CITY OF ALBUQUERQUE  
PLANNING DEPARTMENT  
DEVELOPMENT REVIEW BOARD

**Project# 1004913**  
13DRB-70456 MAJOR - 2YR SUBDIVISION IMPROVEMENTS AGREEMENT  
EXTENSION (2YR SIA)

HIGH MESA CONSULTING GROUP agent(s) for THE UNIVERSITY OF NEW MEXICO request(s) the referenced/ above action(s) for all or a portion of Tract(s) C, UNM LANDS WEST zoned C-3, located on CAMINO DE SALUD NE between I-25 and UNIVERSITY BLVD NE containing approximately 3.1657 acre(s). (J-15)

PLAT OF
TRACTS A-1, B-1 & E-1
U.N.M. LANDS WEST
 (A REPLAT OF TRACTS A, B & E
 U.N.M. LANDS WEST)
 ALBUQUERQUE, NEW MEXICO
 BERNALILLO COUNTY
 APRIL, 2009

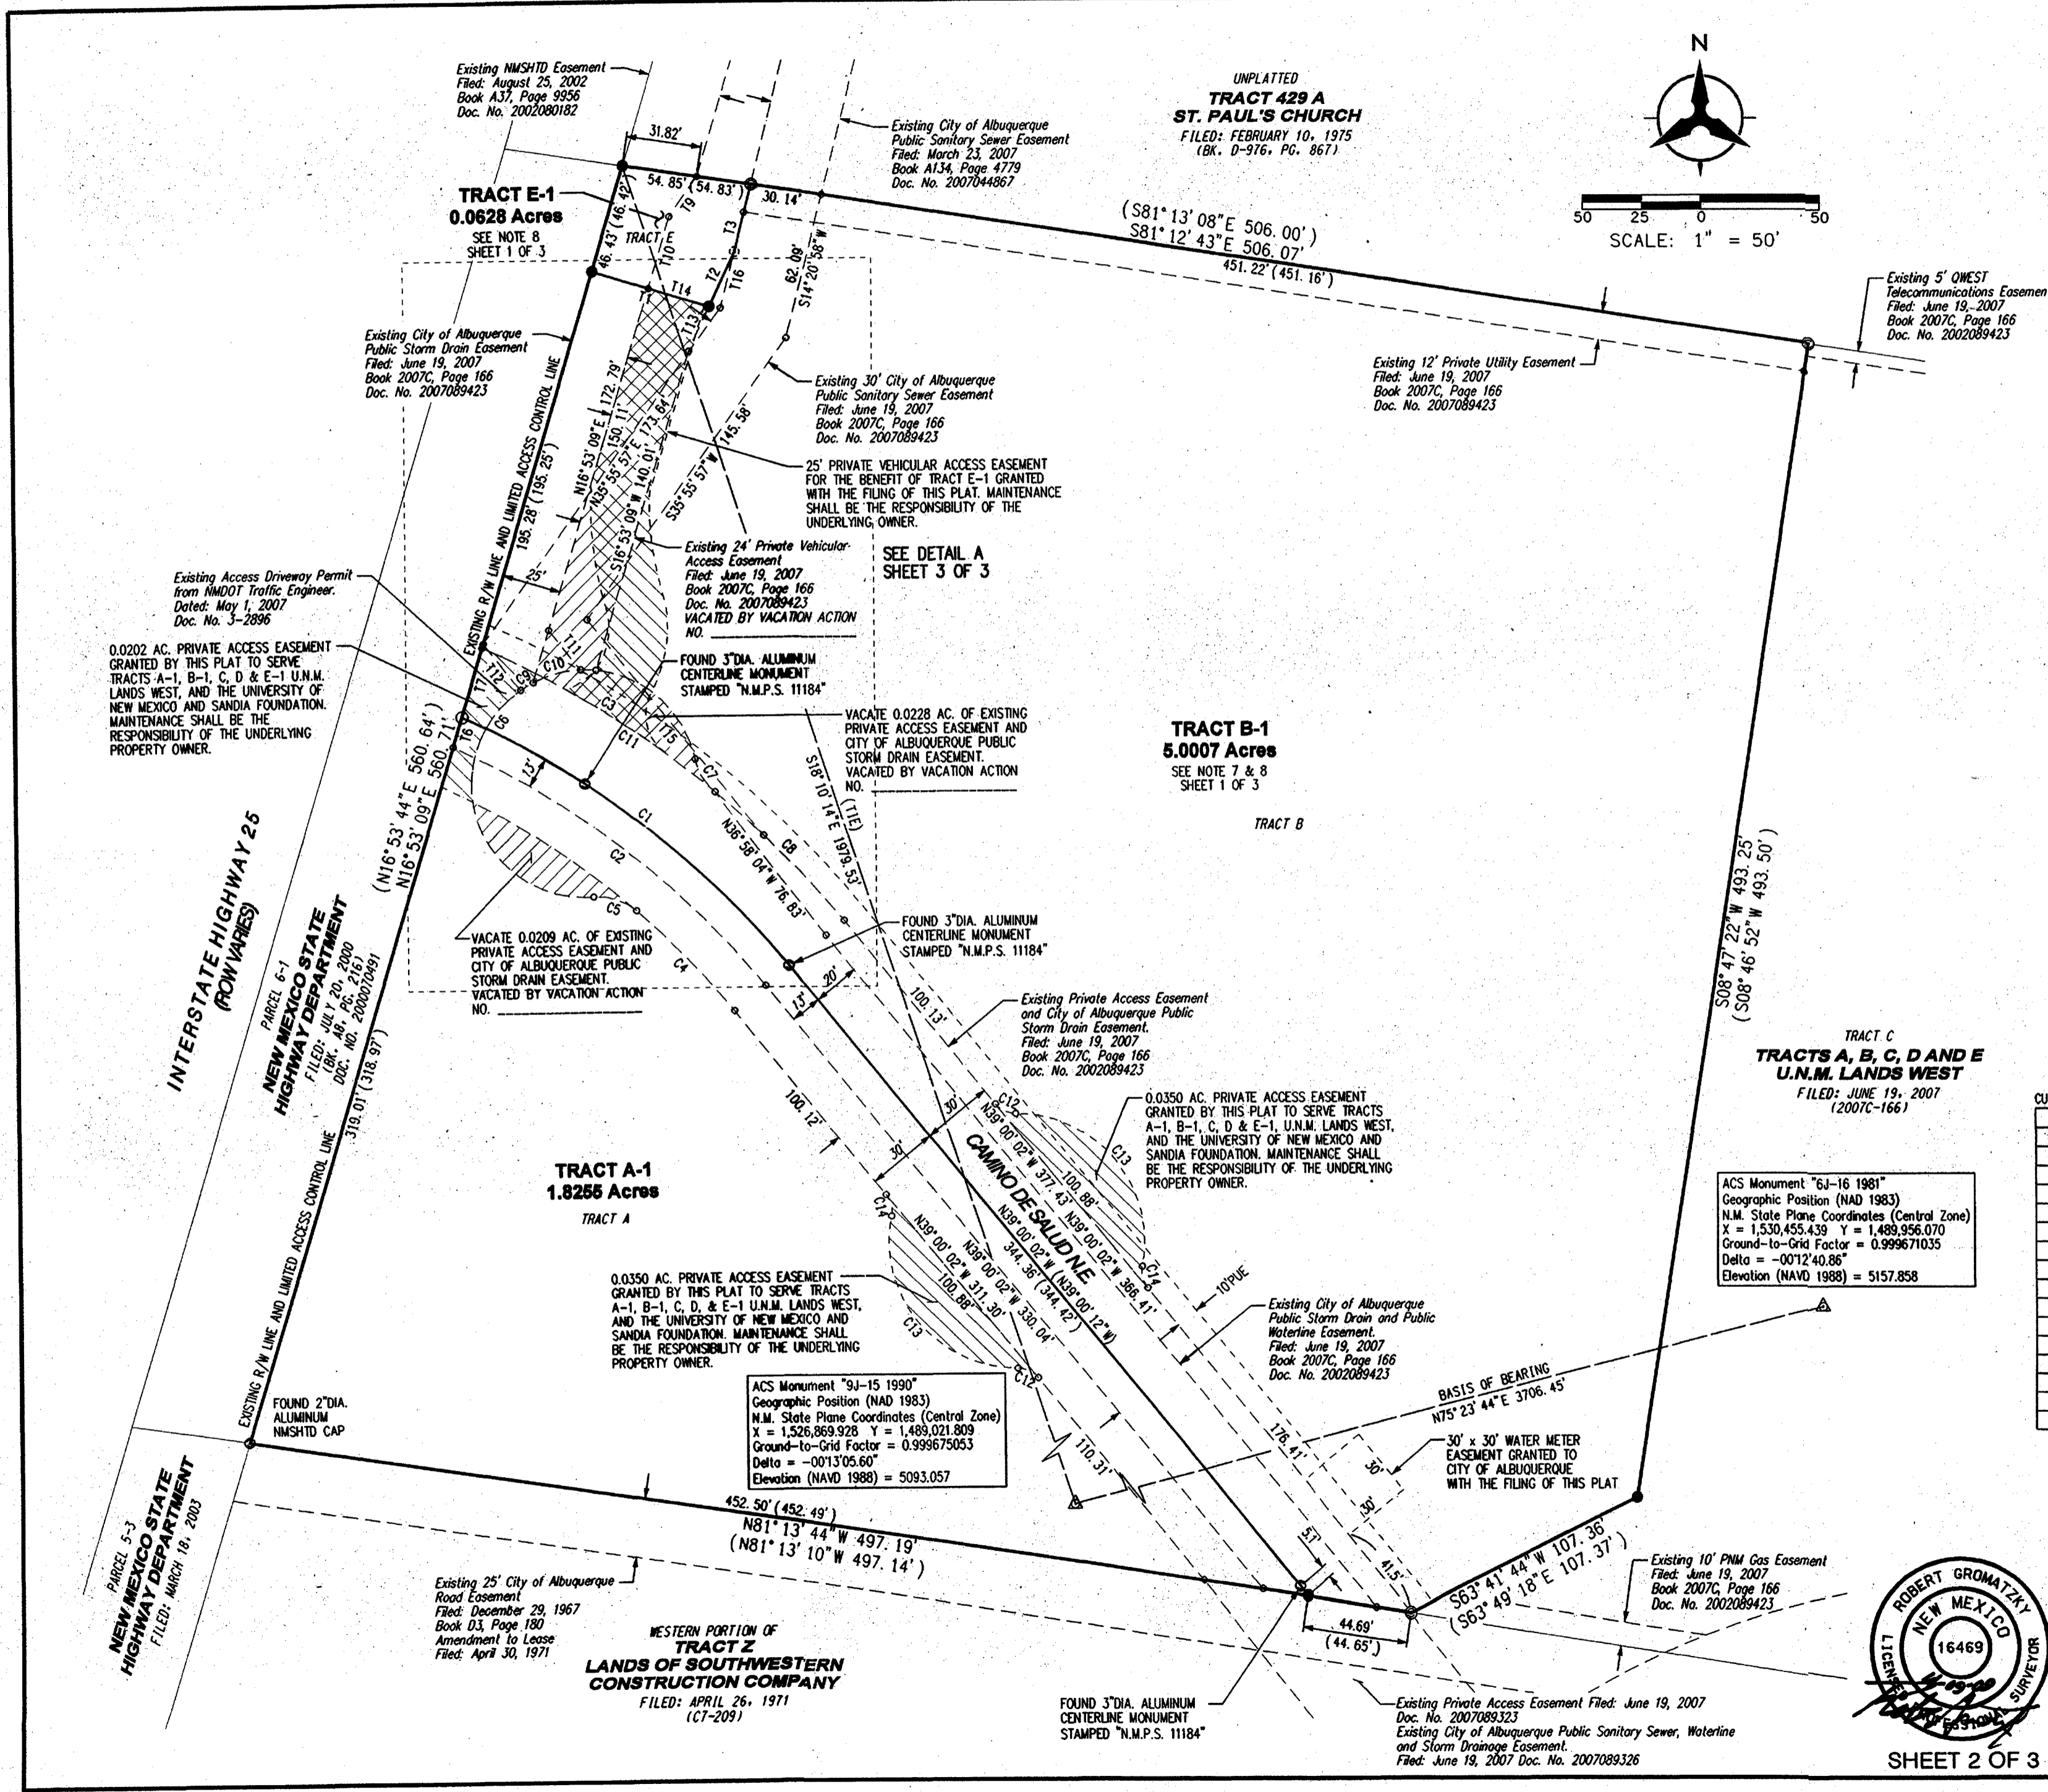
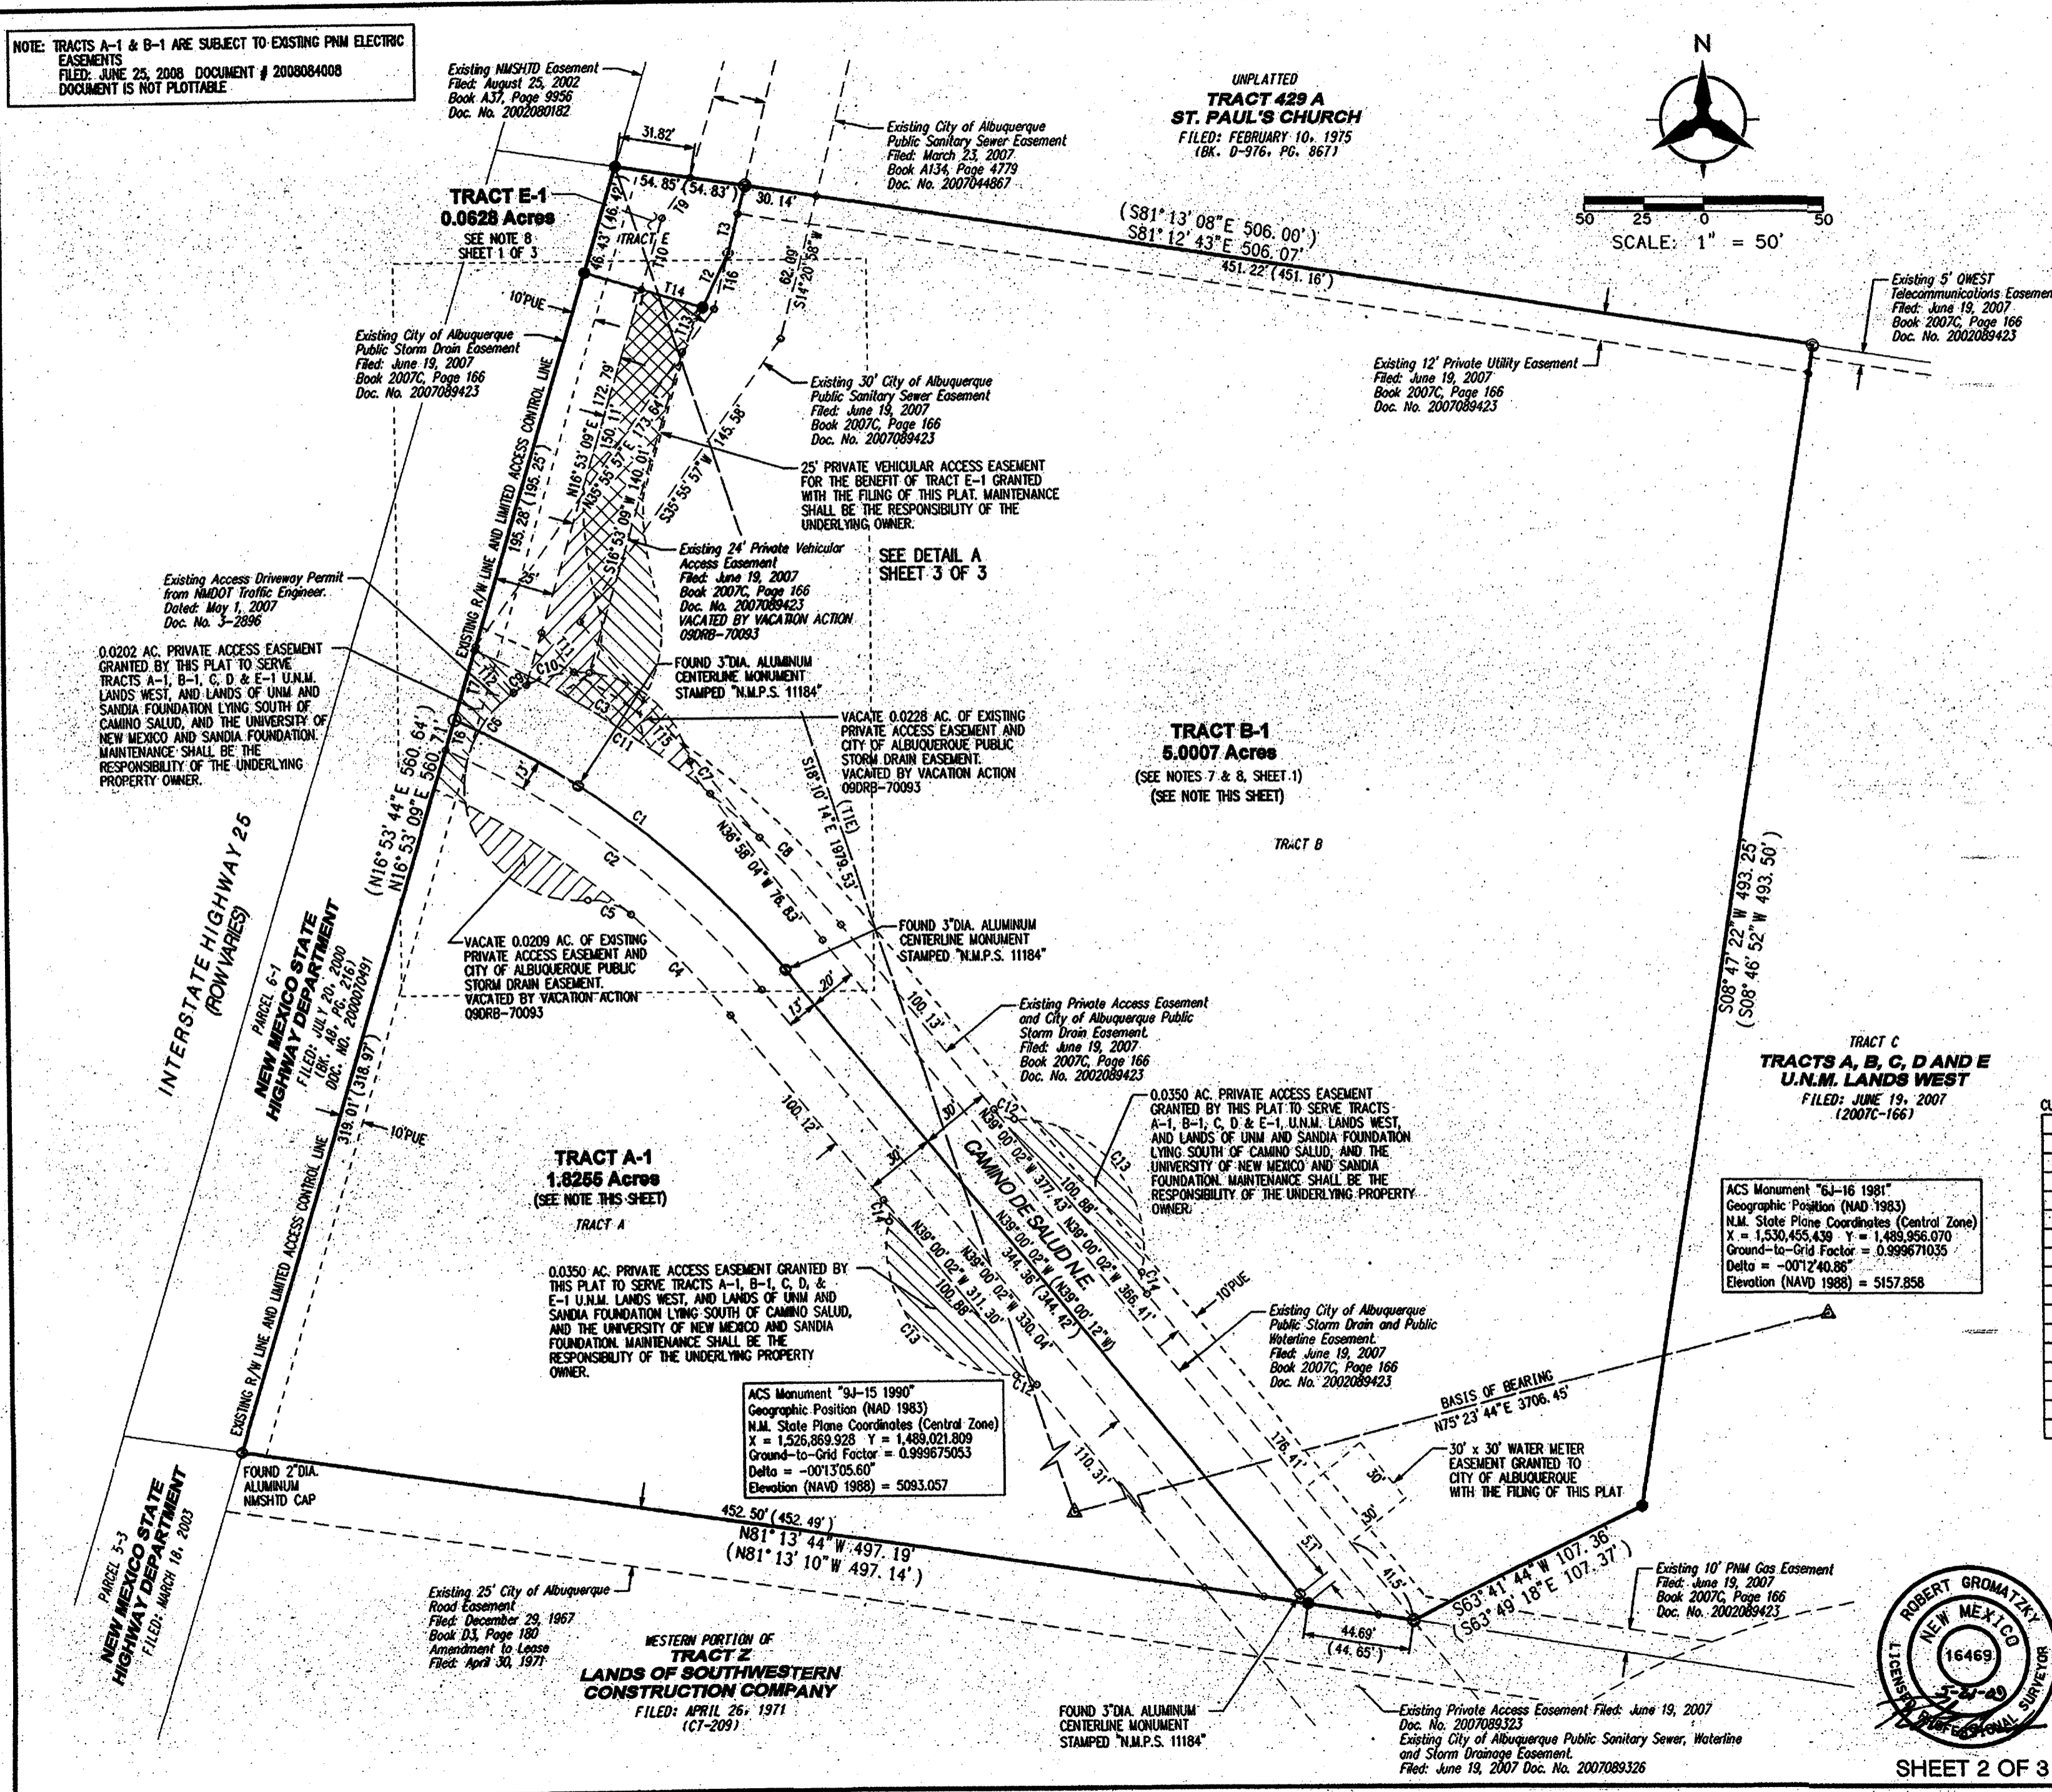
The beneficiary of an easement should be noted as a certain tract of land, not an owner, so that the easement rights run with the land. If the intent is to allow use of the easement(s) on this plat by the unplatted lands to the south and east, some type of legal description (e.g. 'Portions of Tract Z, K, & 5' etc.) should be used rather than ownership.
